## About the application

Application number: 2023/93759	
What is the application for?:	Change of use from storage to garage, erection of single storey side extension a
Address of the site or building:	12, George Street, Ravensthorpe, Dewsbury, WF13 3LL
Postcode:	WF13 3LL

DRAWING No
A1-CAD/01
REVISION /

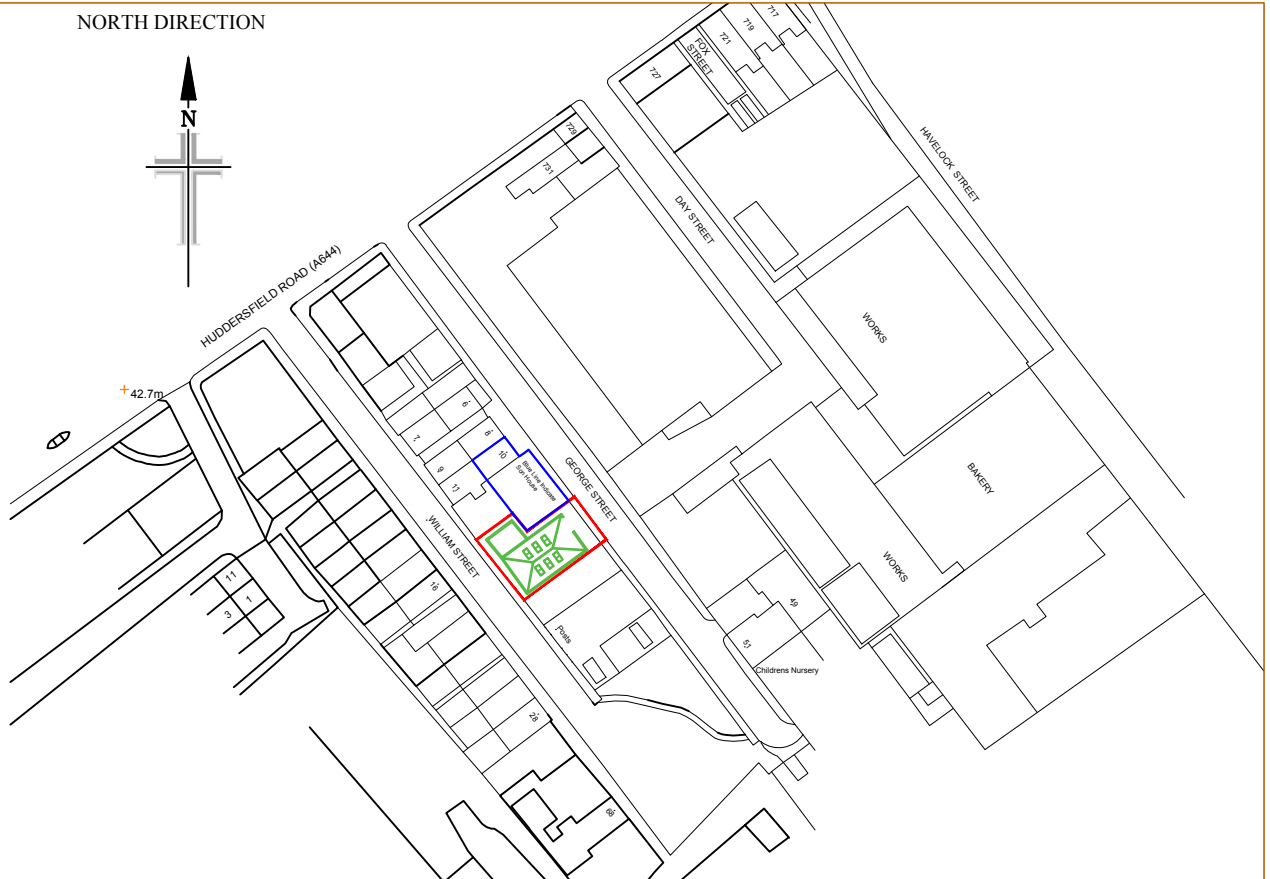
Type of comment: An objection	
Do you wish your comments to be published on the website anonymously?	Yes
<p>The garage has been running illegally without planning permission. Closure 8 stated that the unit could only be used as a storage unit. We don't need any motor garages as there are lots nearby. This garage is continuously disturbing me with loud banging noises. I can't read or pray in peace. I get distracted with these noises. My parents are old and are having trouble sleeping. I have young children, and have noticed the increase in people coming in and out of this street due to this garage. I feel it is unsafe for my children to be out on the street due to lots of people coming to this garage and waiting around. I cannot believe that a planing permission is being considered as there is a nursery nearby to this garage, nursery children are having to walk on road due to this garage, customers waiting around the street, I believe it is a safeguarding concern and planning should be refused. We don't need a motor mechanic garage we need a nursery nearby.</p> <p>Extra council land has also been taken by this motor mechanic garage, without permission. They have levelled it, cut shrubs taken of their boundary fence and put hardcore. They have mischievous intentions to occupy this council land. the planning drawings are incorrect, the metal fence is showing incorrectly.</p>
